1865 WOODMOOR DRIVE

LANDSCAPE PLAN

PPR1830

LANDSCAPE PLAN

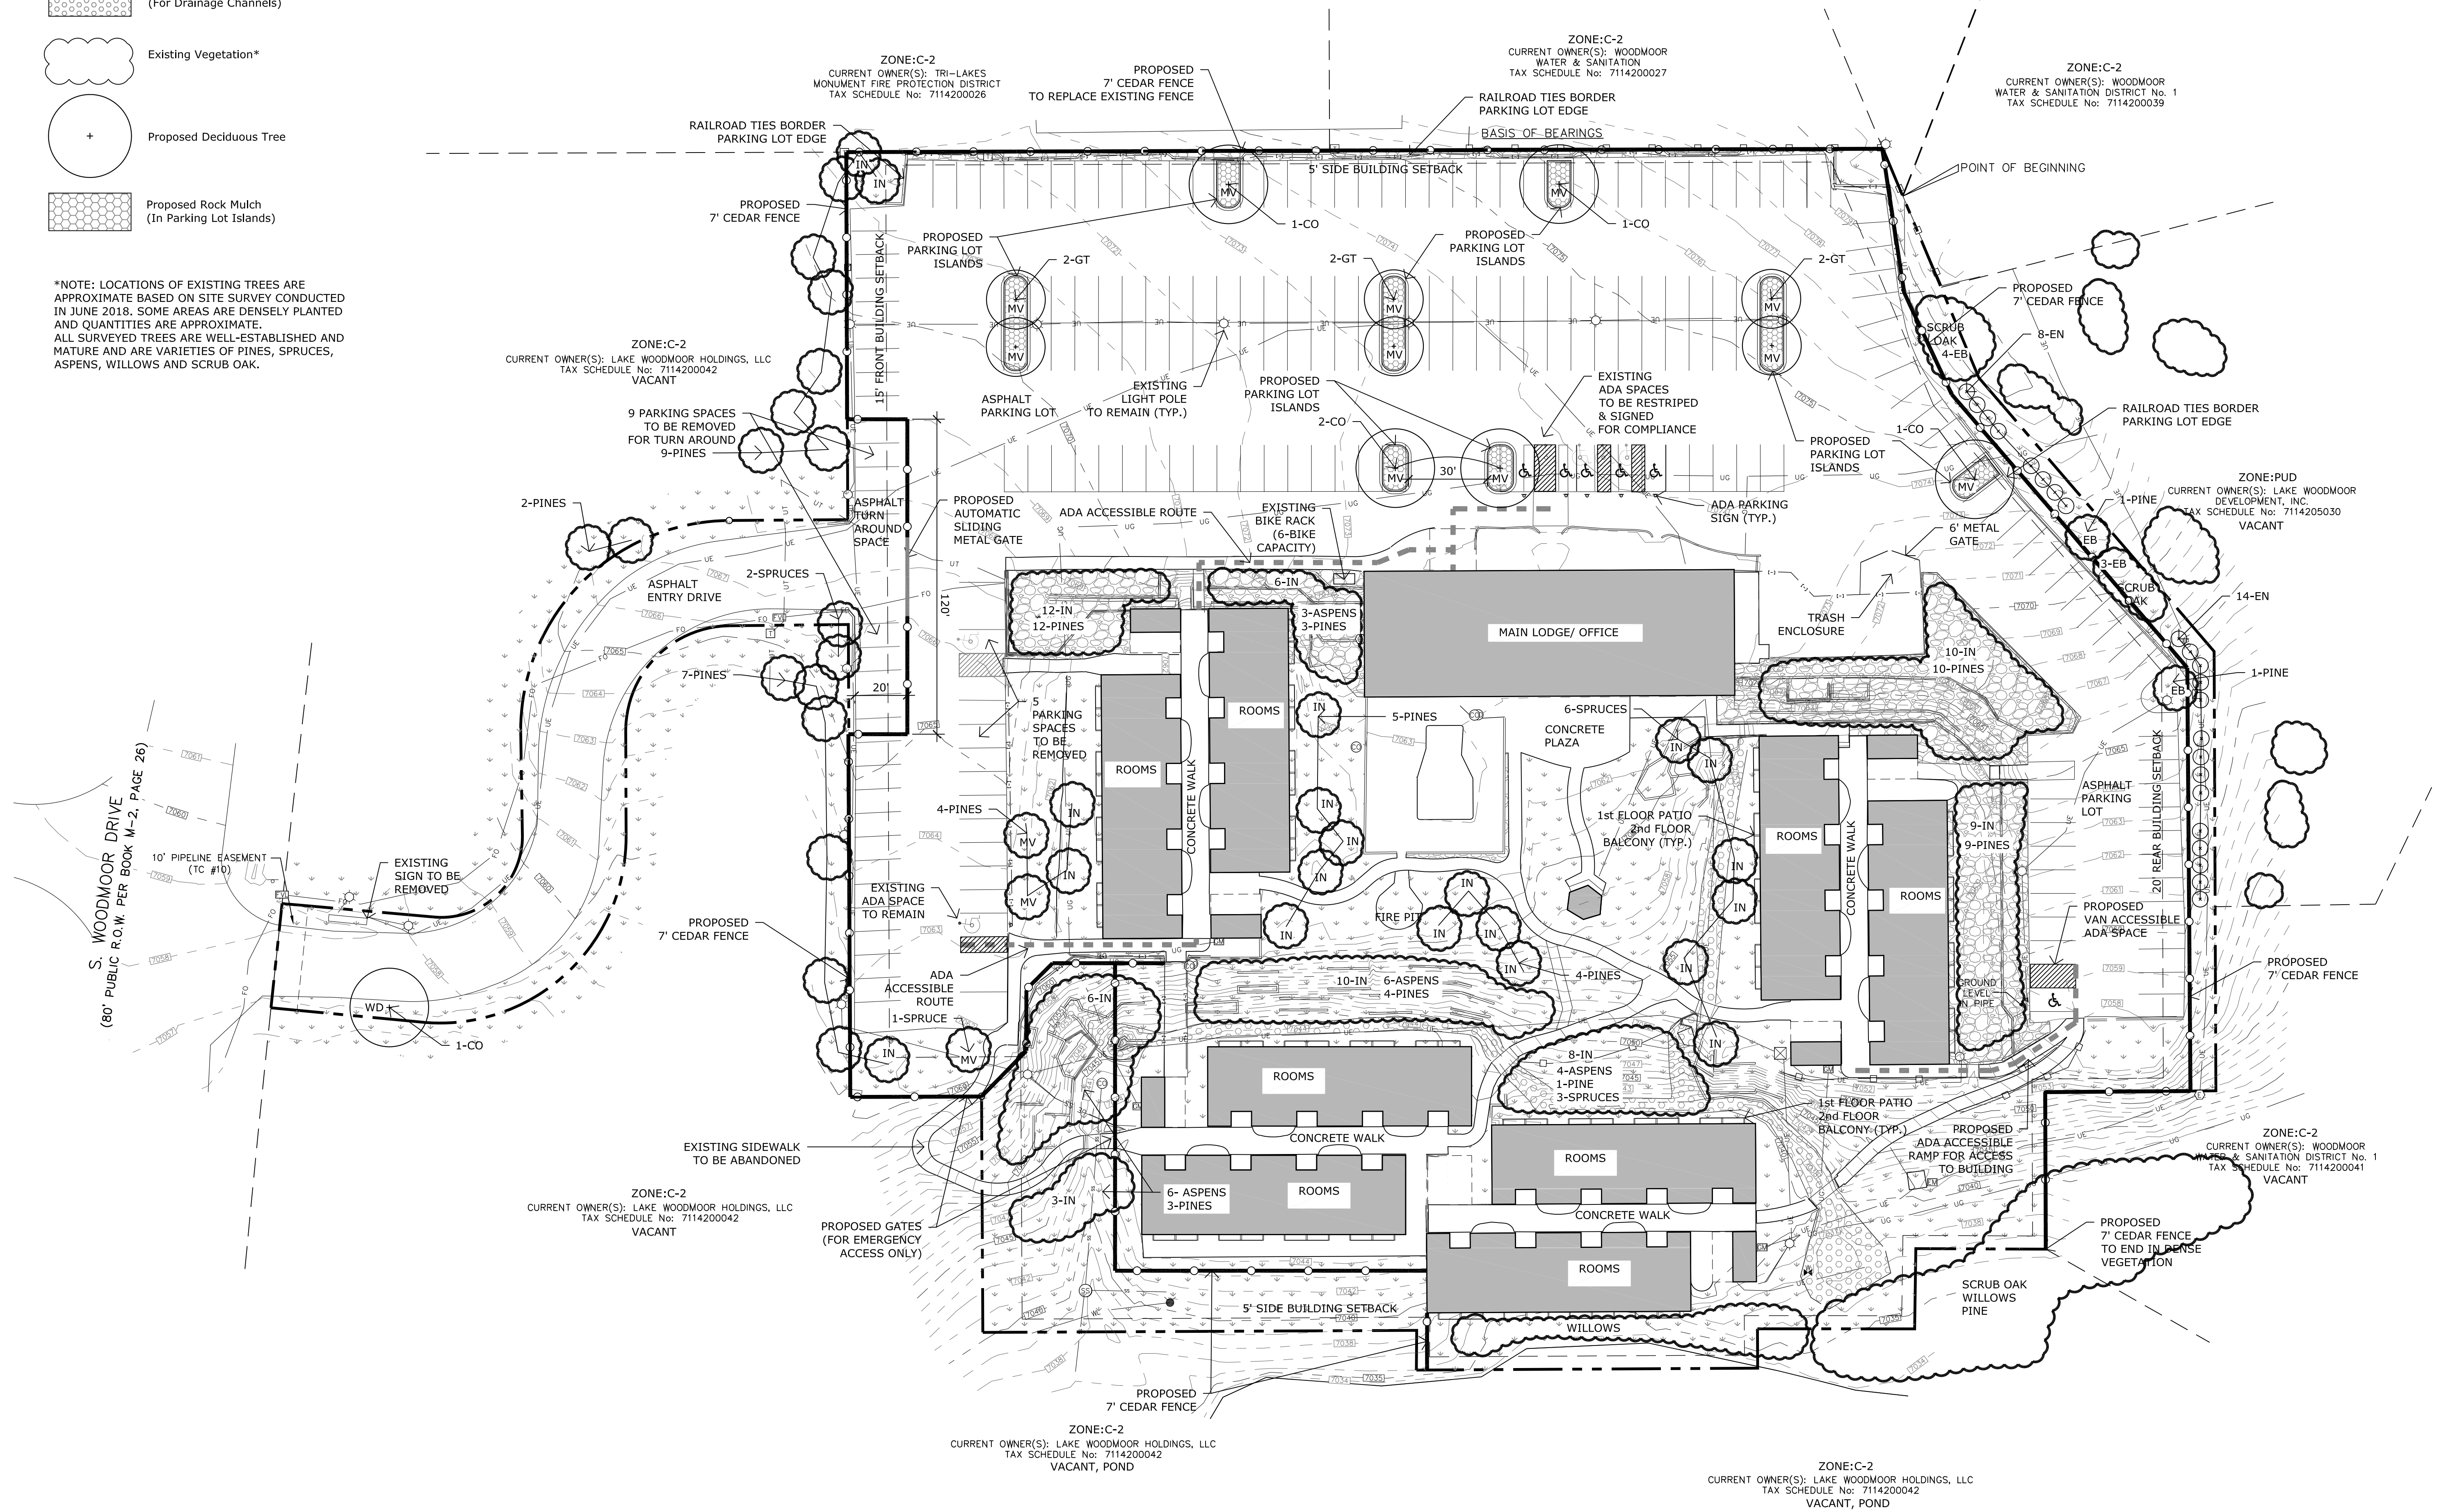
Throughout the site you have not identified the tree type. Please identify the tree type throughout.
